Application no: 22/02848/DISC

Location: Heyford Park, Camp Road, Upper Heyford, OX25 5HD

Transport Development Control

The issues set out below need to be addressed to ensure that the Design Code conforms to current standards

CREATING PEDESTRIAN AND CYCLE PERMEABILITY

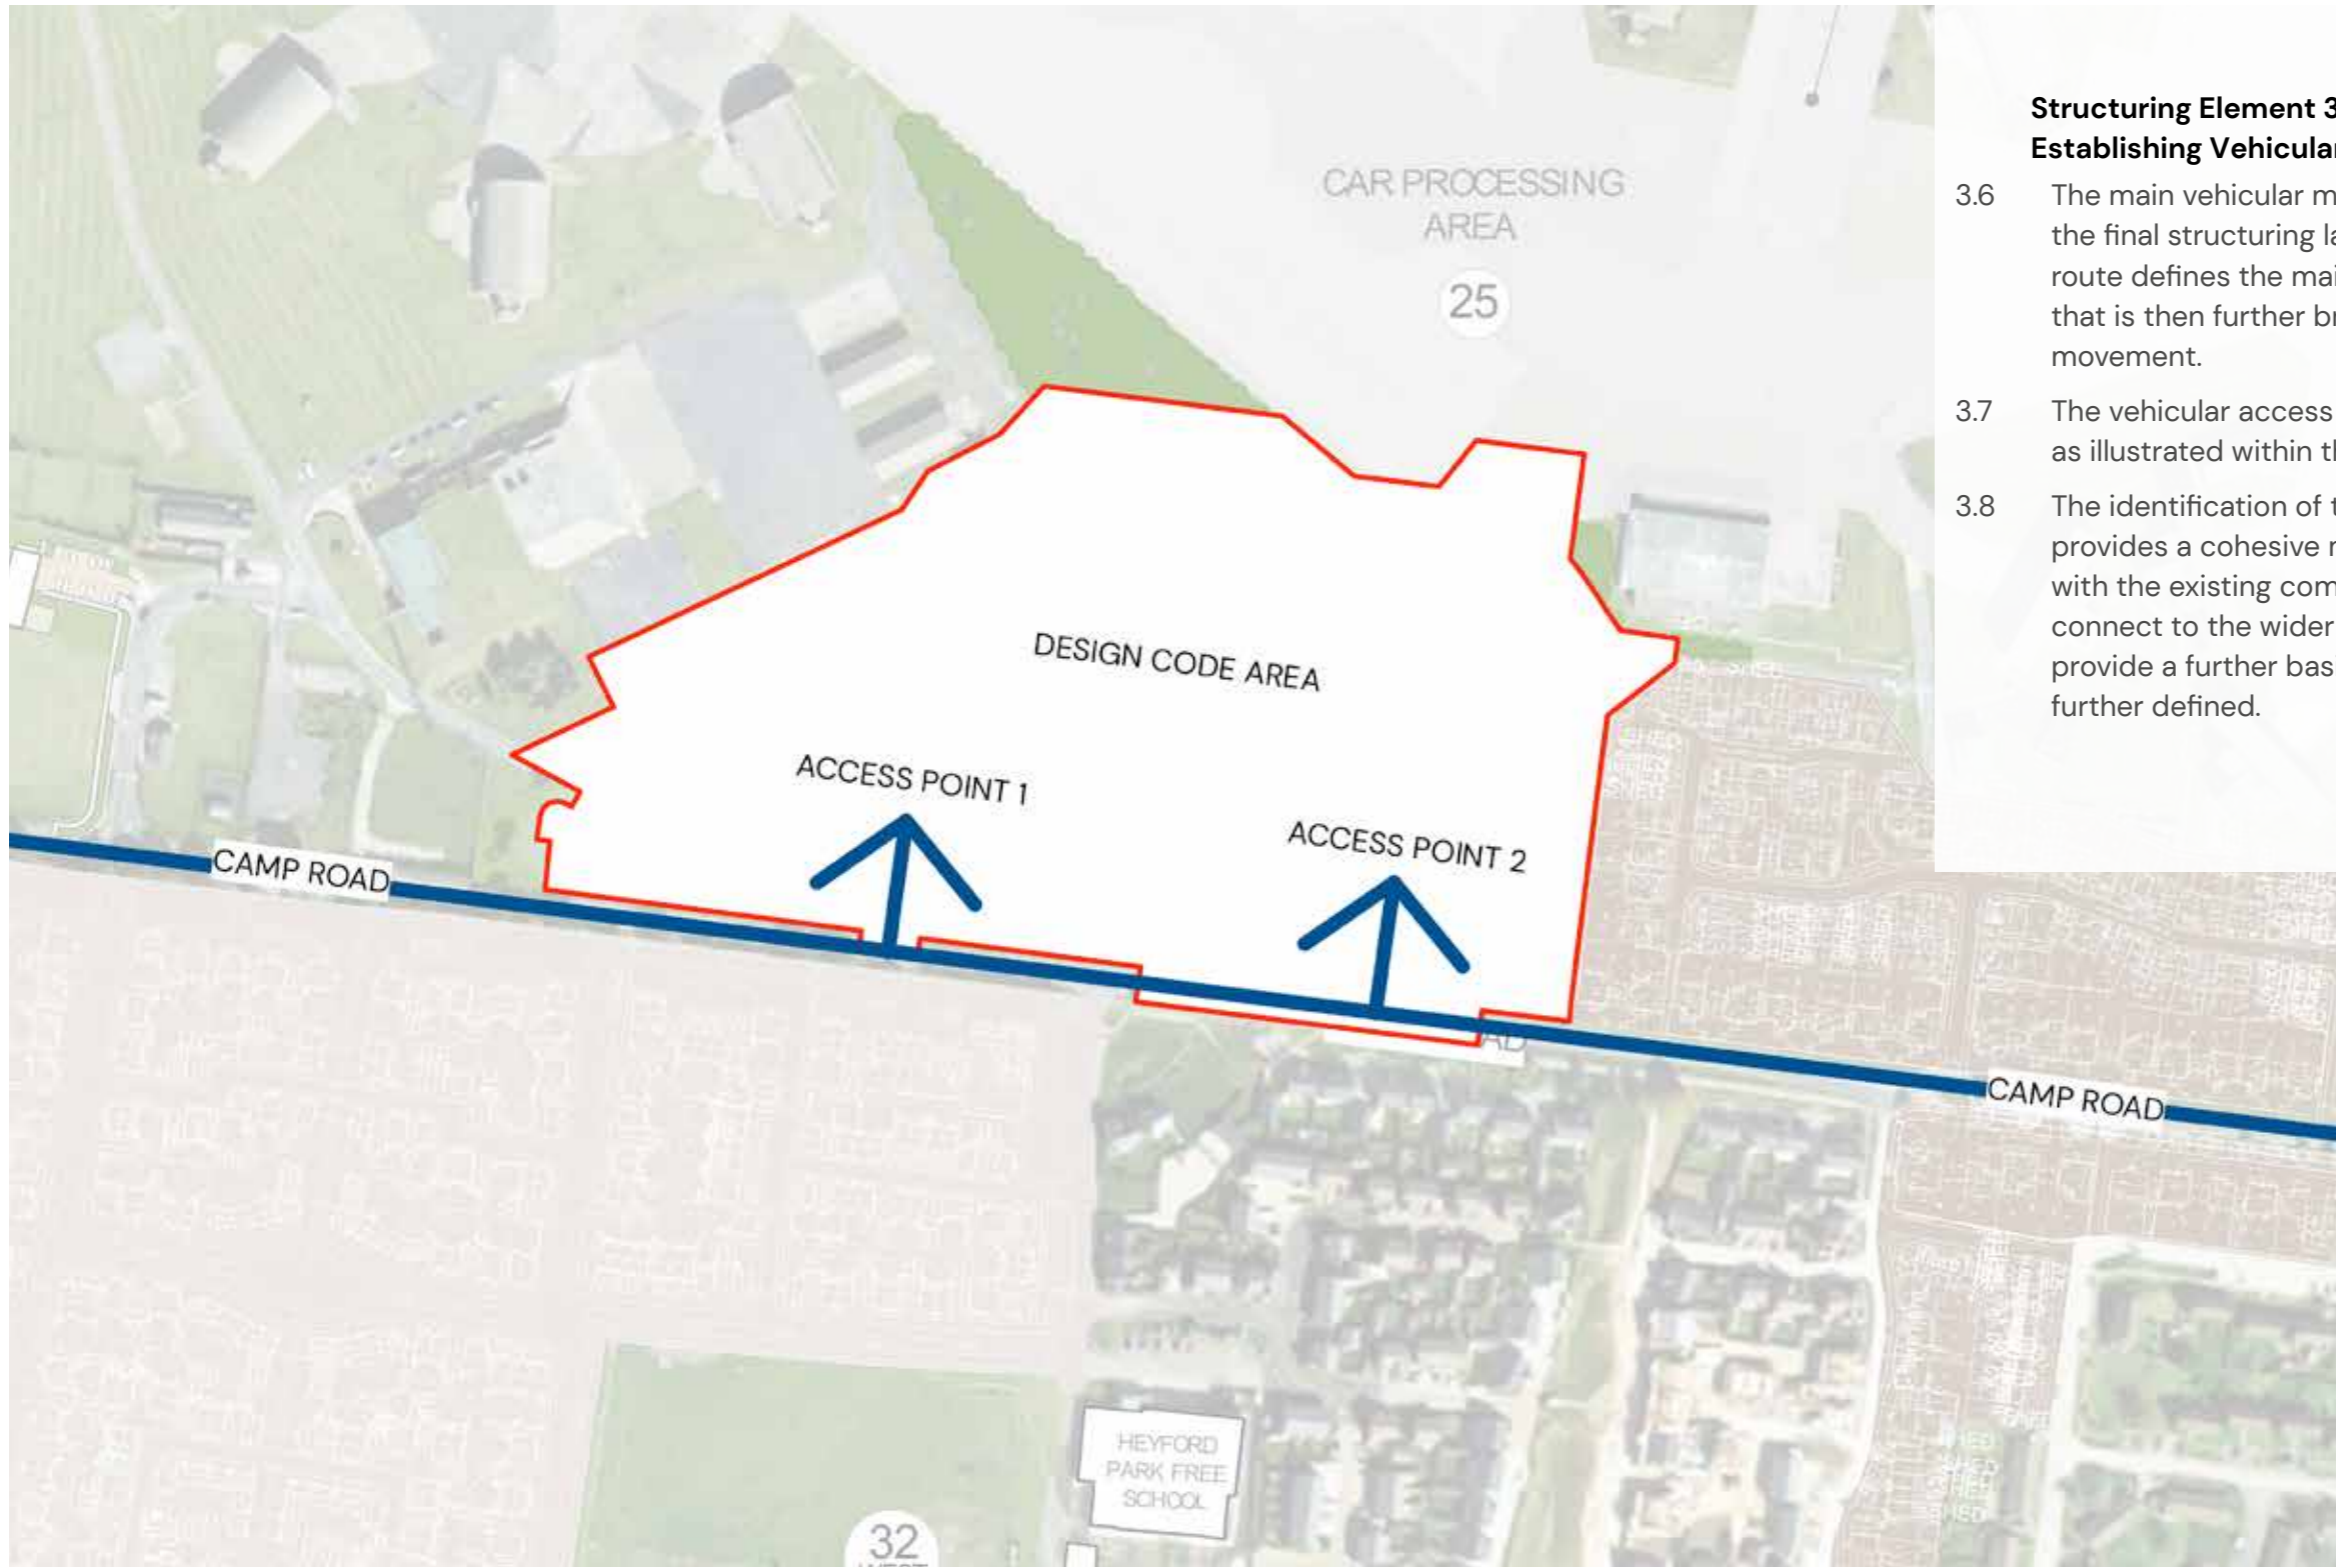
There should be better pedestrian/cycle connectivity throughout the site in accordance with Oxfordshire LTCP Policy 2b. There should be a pedestrian/cycle connection between the west end of the site and Camp Road to reduce walking distances to services within Heyford Park. Internally there are also 2 loop roads with no pedestrian/cycle connectivity between them, OCC's Street Design Guide states within the Street Hierarchy that Pedestrians/Cyclists have top priority within the street scene and therefore greater efforts need to be made to decrease walking and cycling distances. We note that the developer declined to provide a ped/cycle connection between the site and the employment area to the north, on security grounds.

REGULATING PLAN

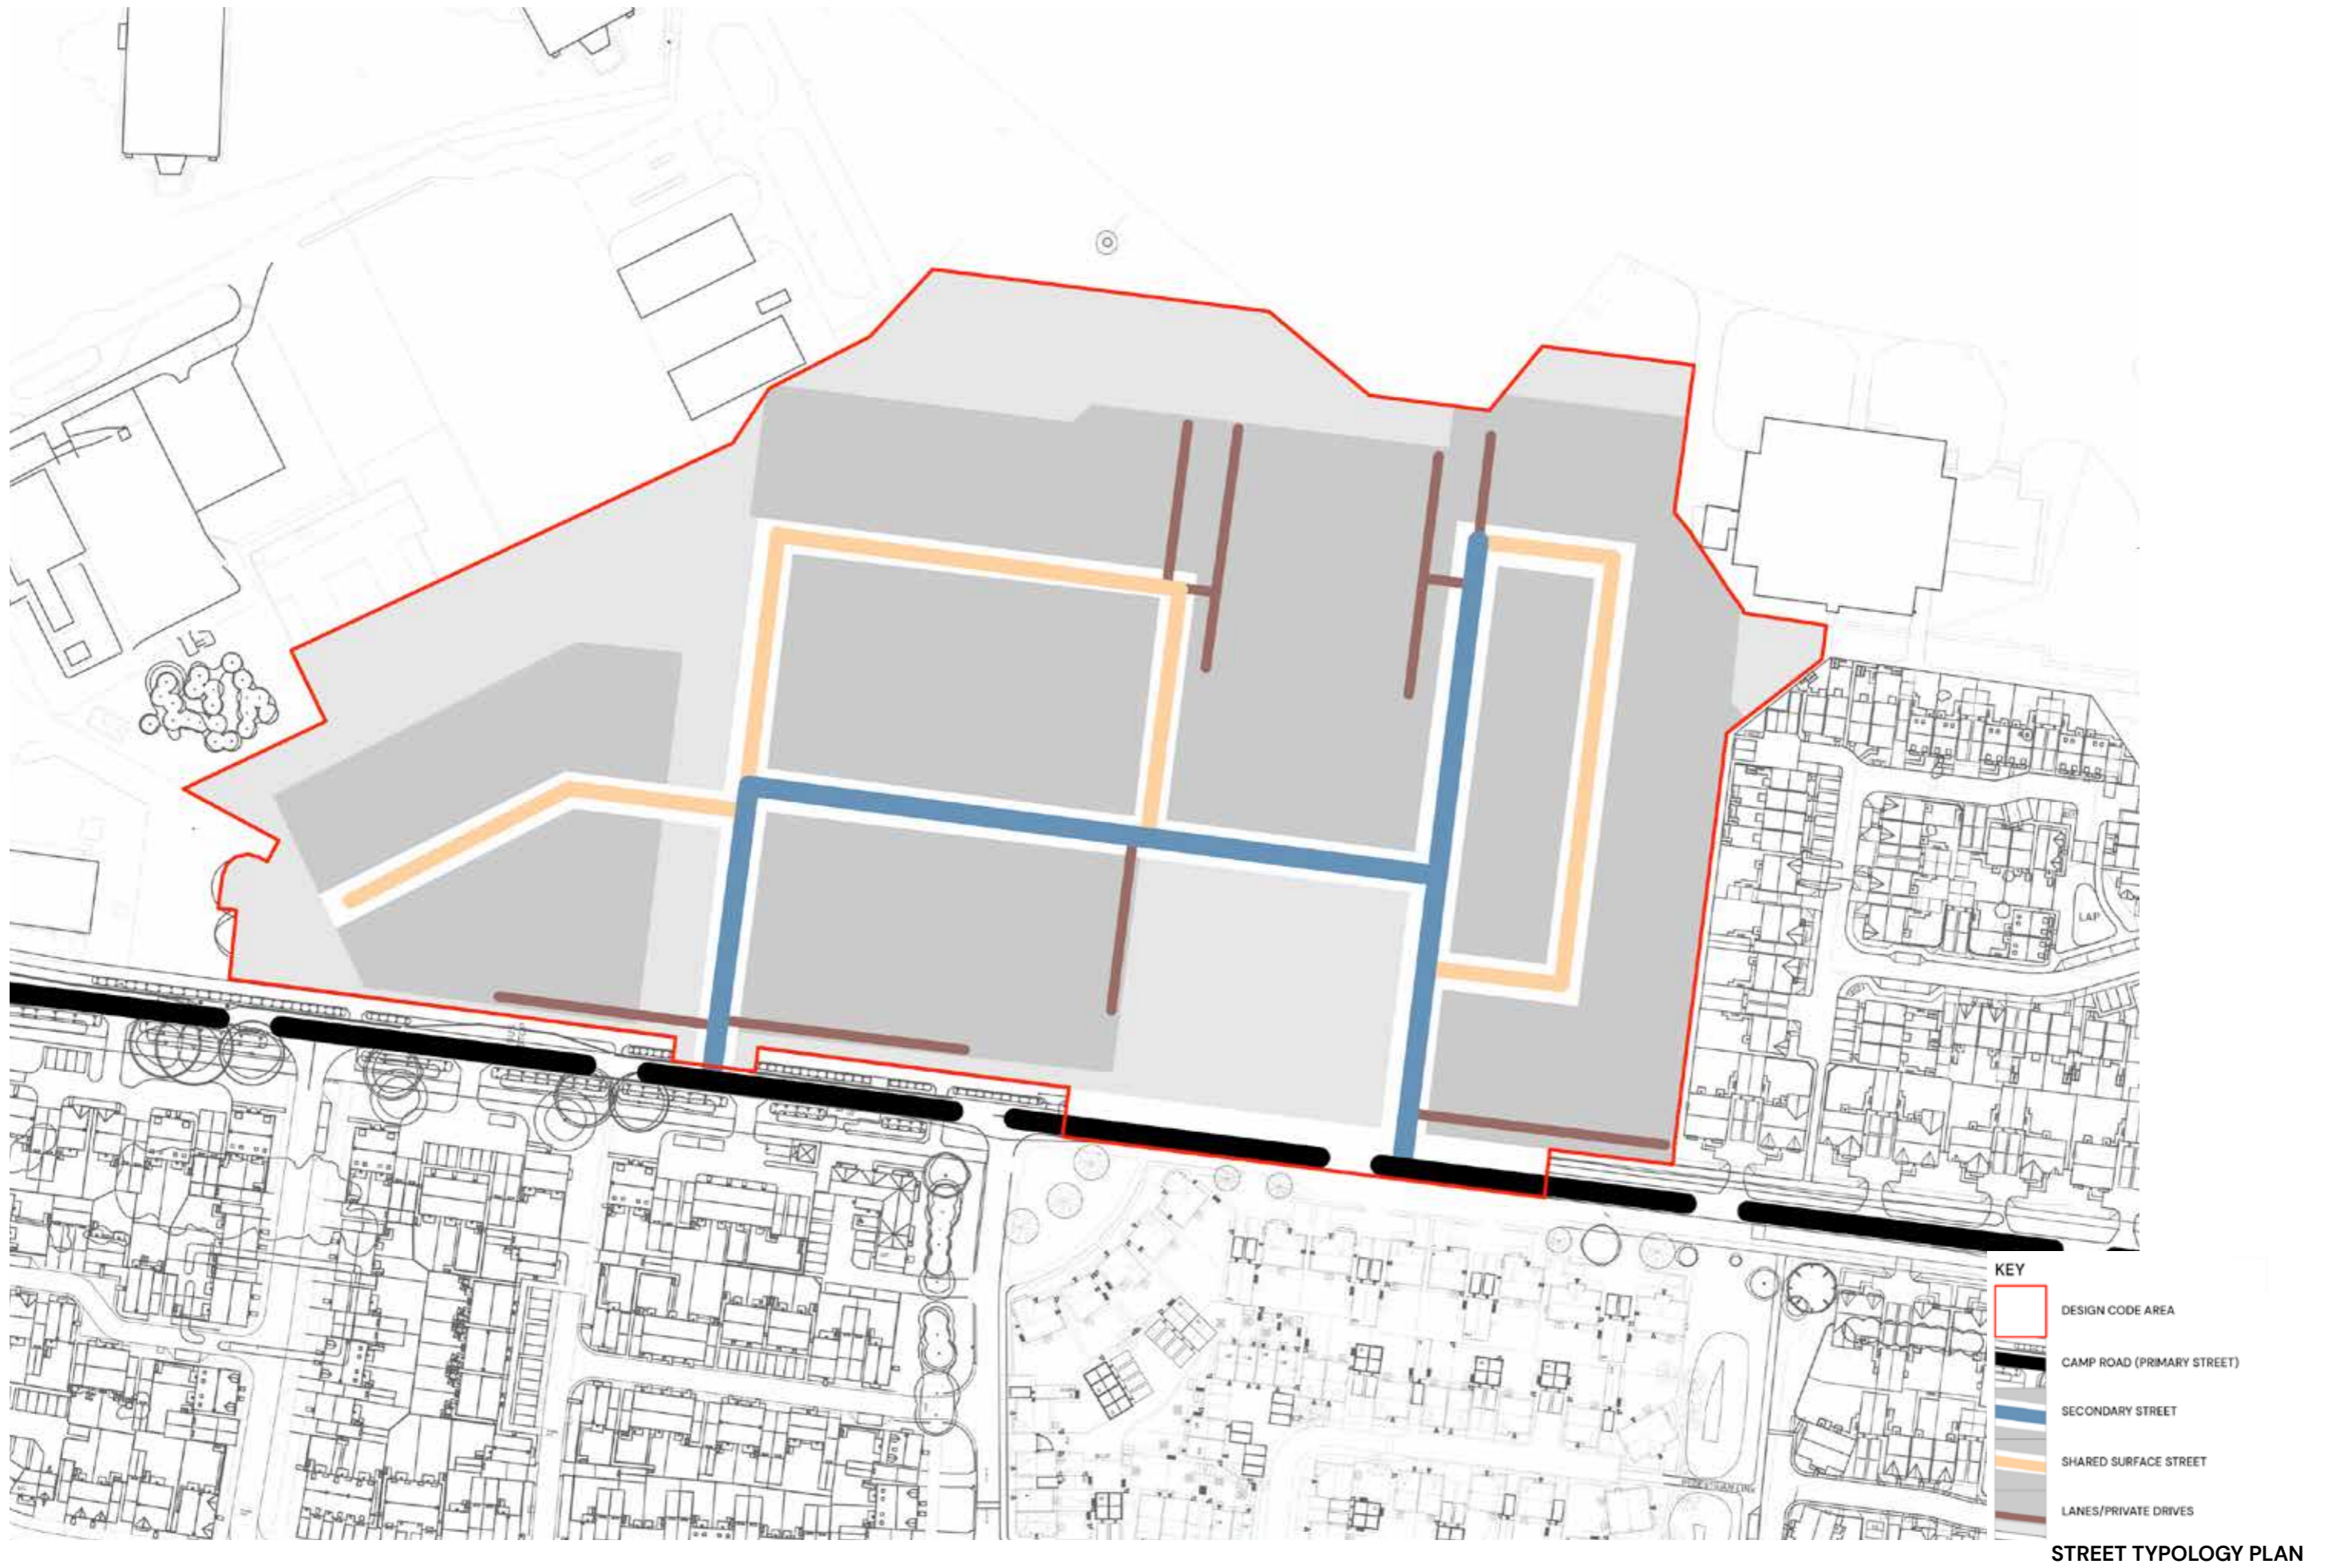
- Design of residential developments should conform to both the Oxfordshire Street Design Guide and LTN 1/20 throughout.
- The Streets marked in blue on page 30 have been labelled as both secondary and tertiary throughout the document. It needs to be clarified which type of street they are.

On page 30 the blue streets have been described as 'Tertiary' streets, however in other places within the document they have been described as 'Secondary' clarification on the type of street this represents is key as it will influence the design criteria it must meet.

Primary Street (Camp Road) is part of the wider Heyford Park development

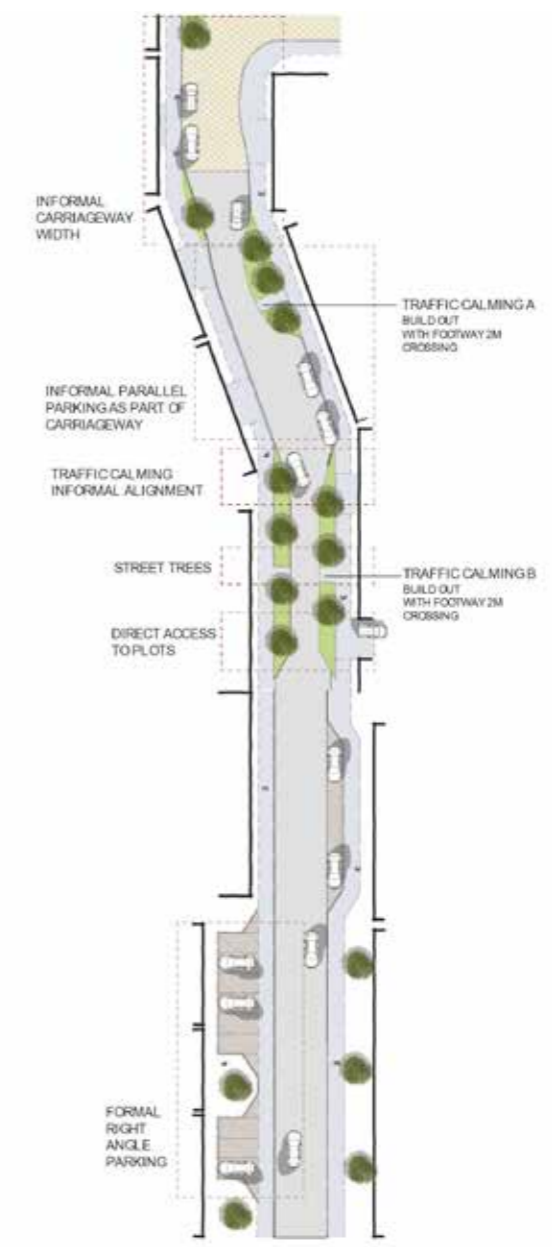
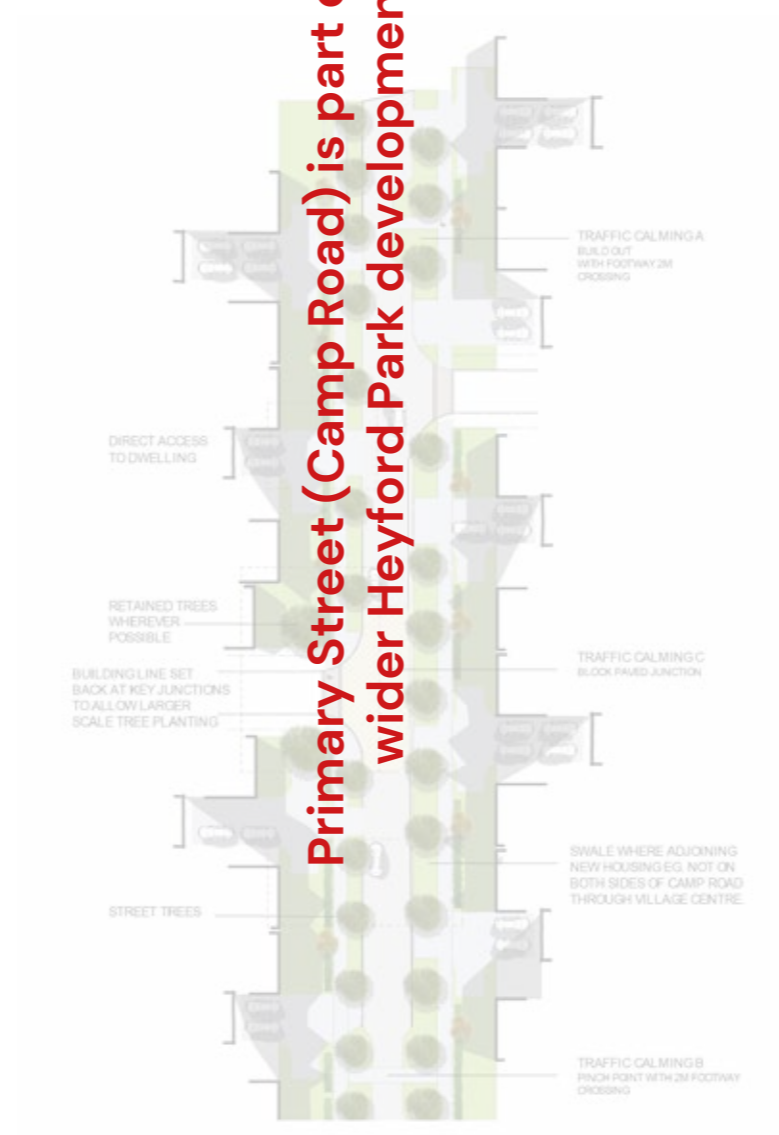
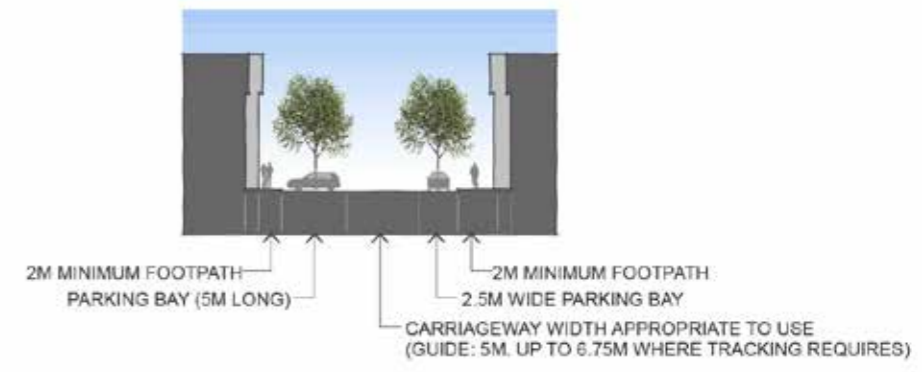
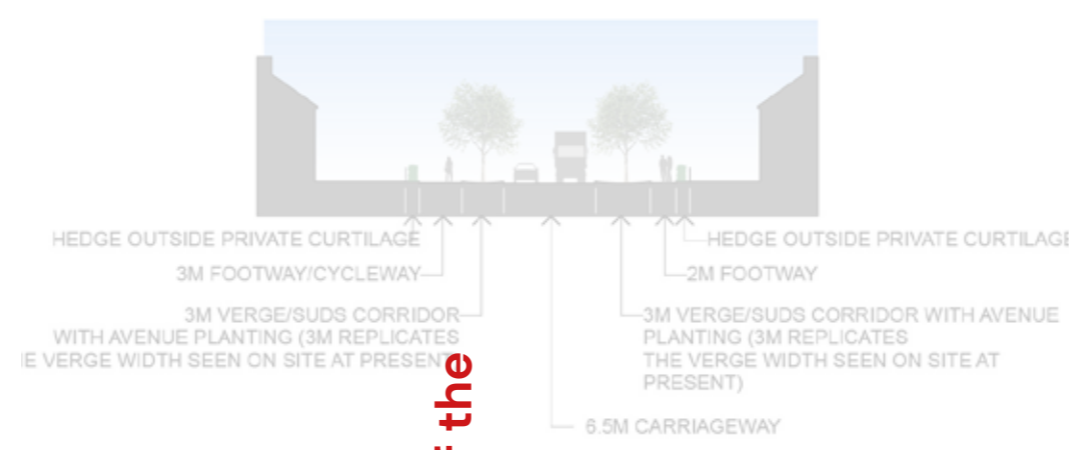
Camp Road is not LTN 120 compliant, table on 33 needs careful review.

Having consulted OCC Road Agreements, they have also outlined that that forward visibility on a 20pmh road must measure at least 25m not the 10 outlined on page 33. The junction radii of 4m are sufficient, however it must be demonstrated that refuse and emergency vehicles can use the junctions without over running.

- Kerbs on Camp Road are to be flush adjacent to swales (to allow over-the-edge drainage) but need to be 125mm upstand HB when adjacent to footways.
- Kerbs on the shared surfaces need to be a minimum of 50mm upstand for asphalt carriageway (to allow for surface dressing if required) – 25mm is acceptable for block paving.

- No central pinch points on Camp road calming. Just the left or right buildouts.
- The original central pinch points have been modified over time
- Any ramps on Camp Road to be bus friendly, they are not to be block paved.

TYPICAL INDICATIVE PLAN SECTION
SHARED SURFACE

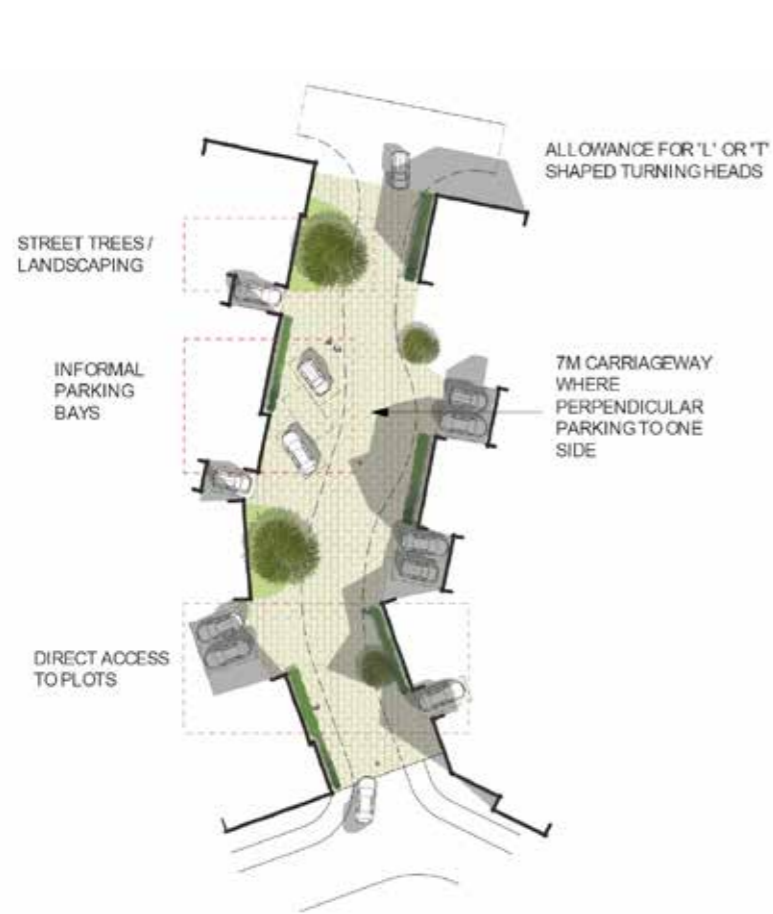
Any shared surfaces must be a width of 6.0m of clear carriageway (with an additional 1m for parking on one side and 2m for parking on both sides), this allows for sufficient room for vehicles and pedestrians. A minimum of 800mm maintenance margin on either side outside the kerbs, this is needed for maintenance access and because streetlighting columns cannot go in the shared surface. Perpendicular parking is not adoptable.
